**From:** Gemma Magnuson  
**Sent:** 10 December 2020 09:47  
**To:** DC Support  
**Subject:** FW: 20/02816/LB - The Lion, Main Street, Wendlebury

**From:** Jennifer Ballinger <Jennifer.Ballinger@Cherwell-DC.gov.uk>  
**Sent:** 09 December 2020 15:26  
**To:** Gemma Magnuson <Gemma.Magnuson@cherwell-dc.gov.uk>  
**Subject:** 20/02816/LB - The Lion, Main Street, Wendlebury

Drawing Title  
proposed extract

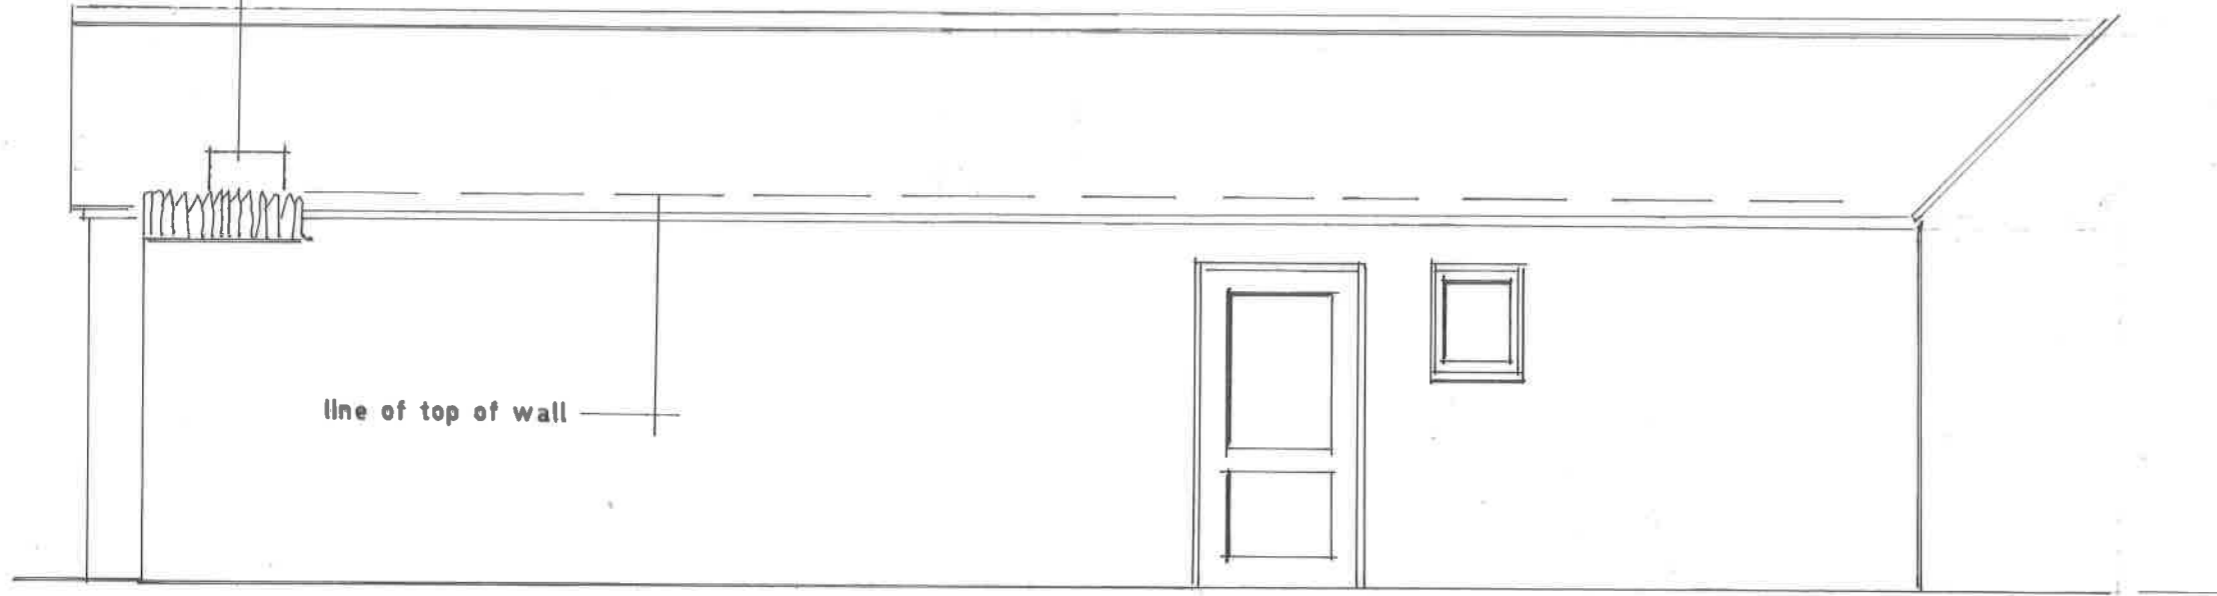
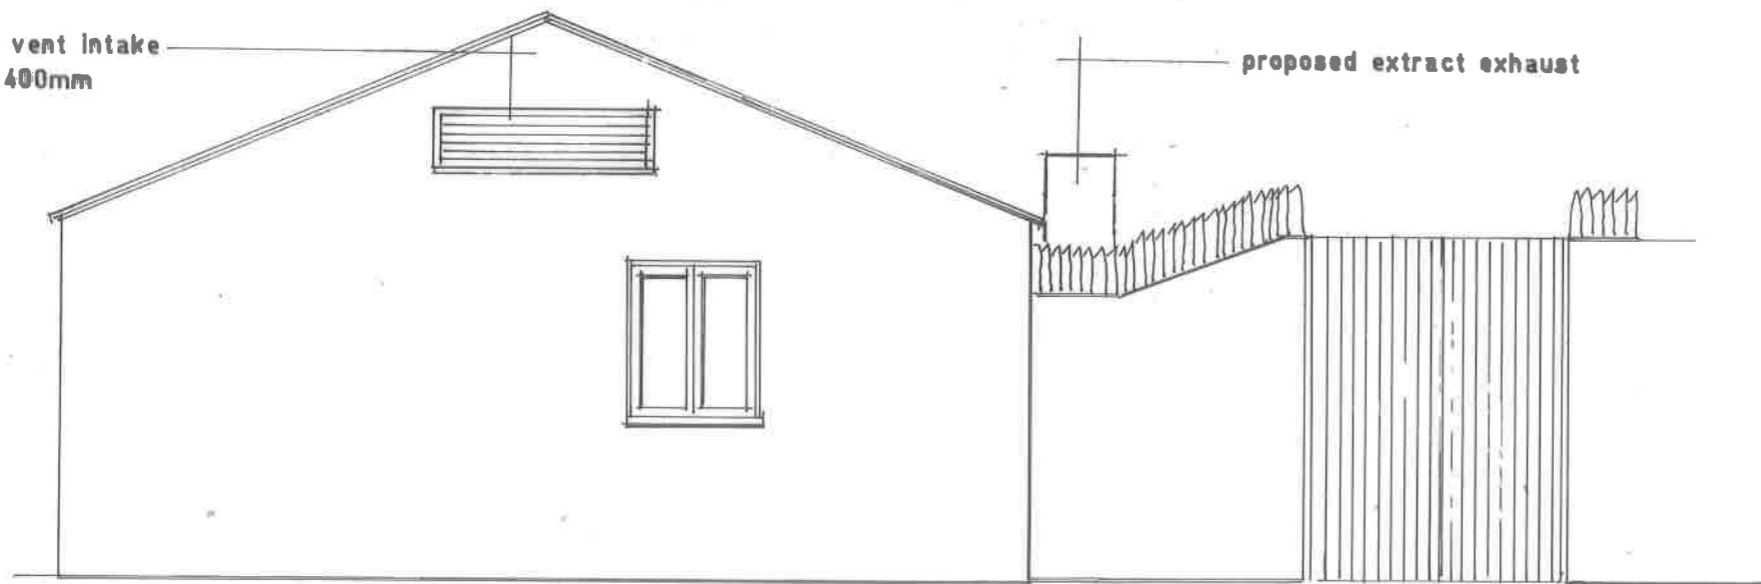
Since that pre-app an alternative scheme has been worked up which involves an intake extract as a grill on the gable end of the building and a separate extraction unit adjacent to the building. This is considered to be a suitable compromise and although still visible reduces the impact on the listed building considerably.

As the kitchen has been given consent in this location (a number of years ago) there are no objections to the extraction system as proposed, which will significantly reduce the impact on the setting of the listed building.
